From: Ryan Bennett <rbennett@portauthoritynsw.com.au>
Sent: Monday, 13 July 2015 2:28 PM
To: Ben Eveleigh
Cc: Richard Lorraine
Subject: Port Authority response to exhibiton of SSD 6611 - Cockle Bay Marine Structures Renewal

Cockle Bay Marine Structures
Developed Design
General Arrangement Plan

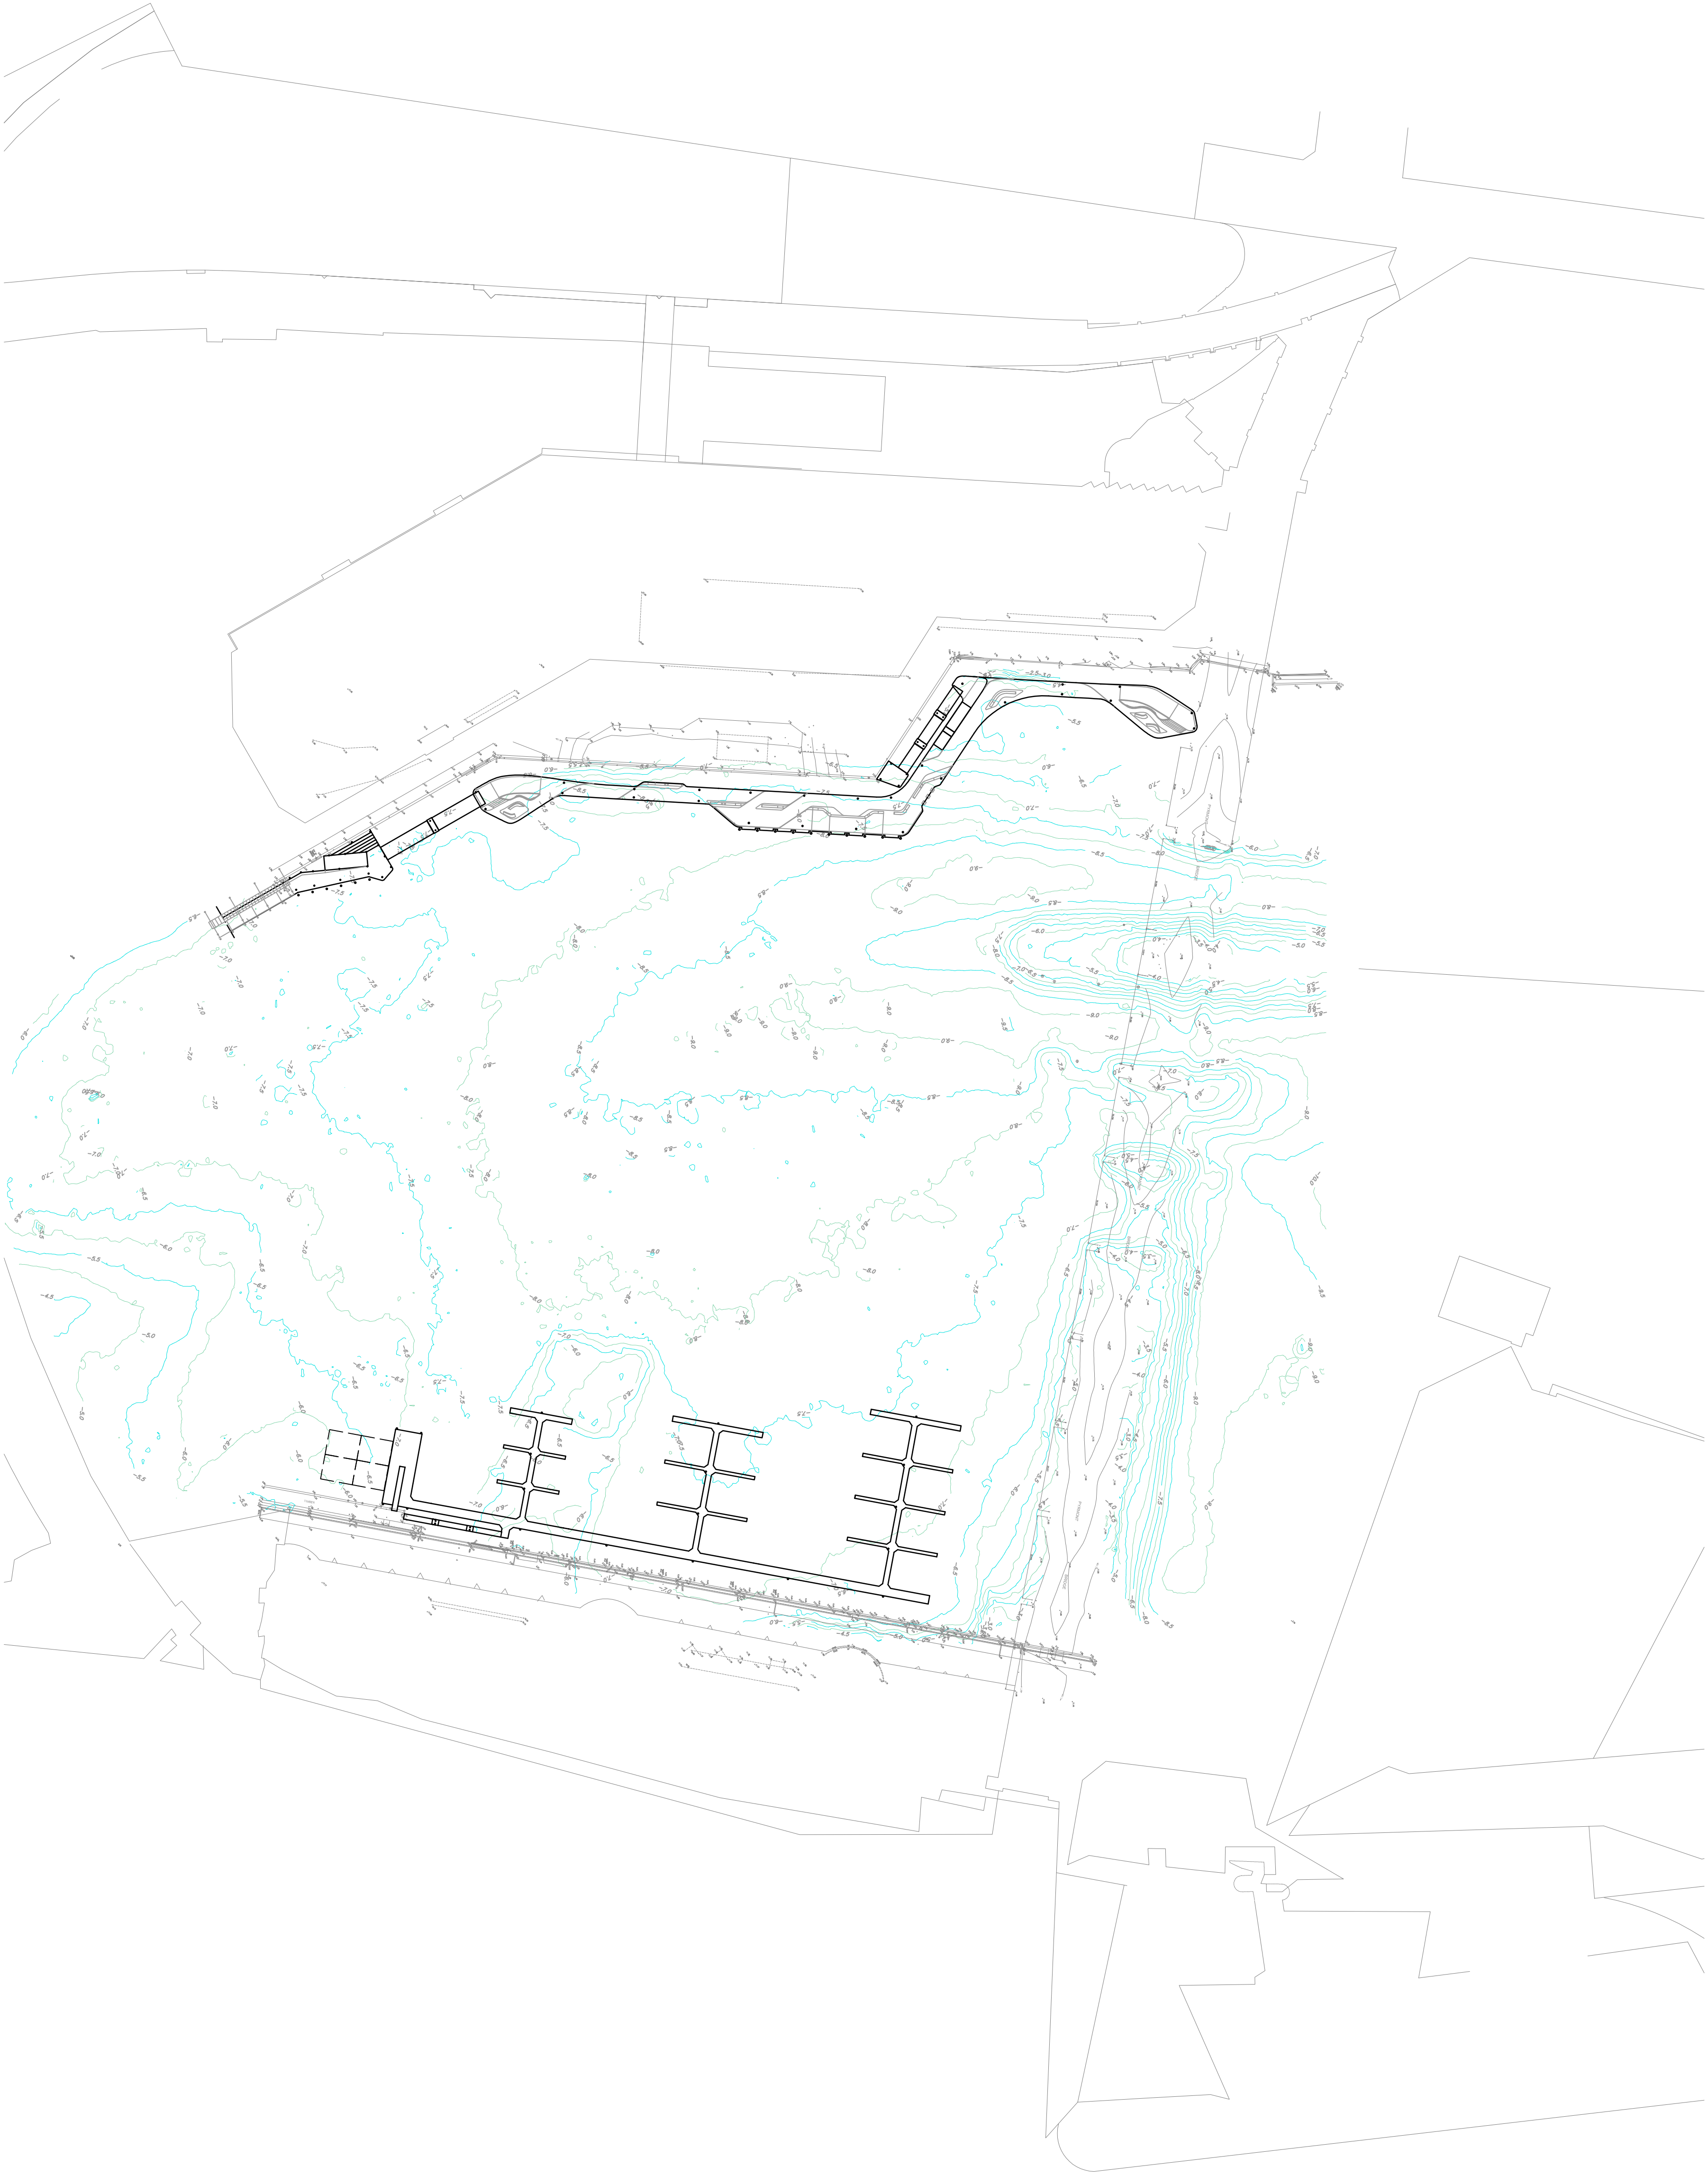
Port Authority of NSW reiterates the comments noted in Table 6 of the EIS and notes the commitments made by SHFA. Port Authority recommends that the conditions of consent require that the Proponent consult with Port Authority of NSW prior to the commencement of construction to ensure that:

- our requirements are met; and
- Harbour Master approval for the disturbance of the seabed under clause 67 of the Management of Waters and Waterside Lands Regulations – NSW is obtained.
